SADDLEHORN RANCH - FILING 5

PRE-DEVELOPMENT GRADING AND EROSION CONTROL PLANS

EPC STORMWATER REVIEW COMMENTS
IN ORANGE BOXES WITH BLACK TEXT

PCD-ENGINEERING REVIEW COMMENTS
IN BLUE BOXES WITH BLUE TEXT

Table VT-1

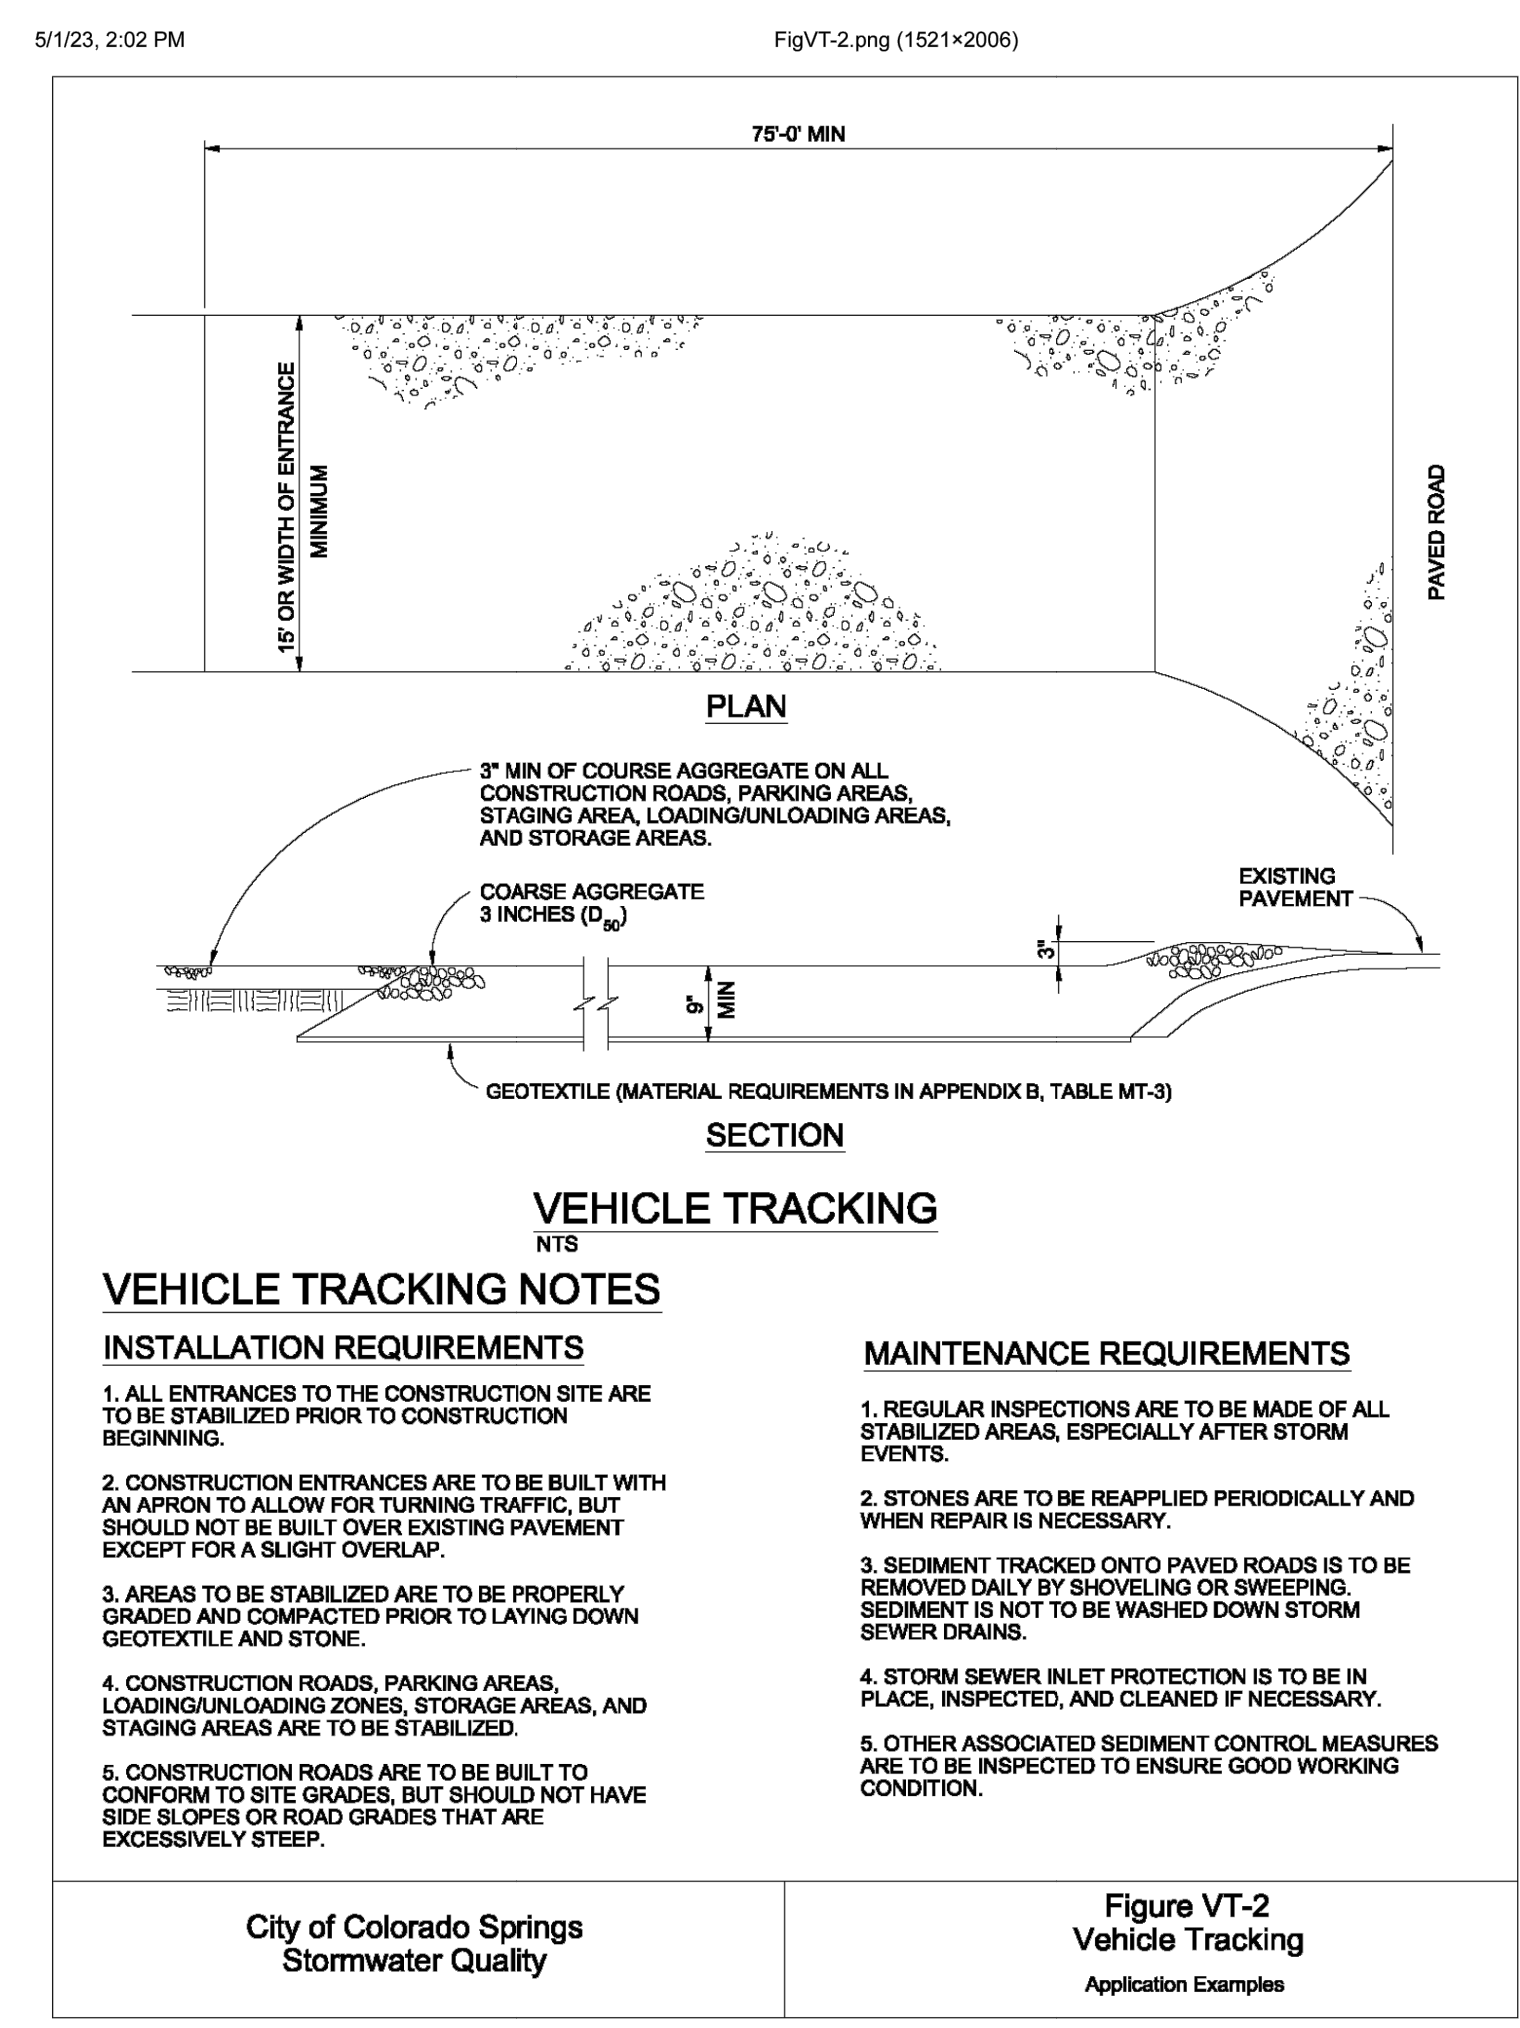
Replace with EPC approved VTC detail (VT-1 and VT-2 in DCMv2, Chap 3.3) or revise to be 75ft min length.
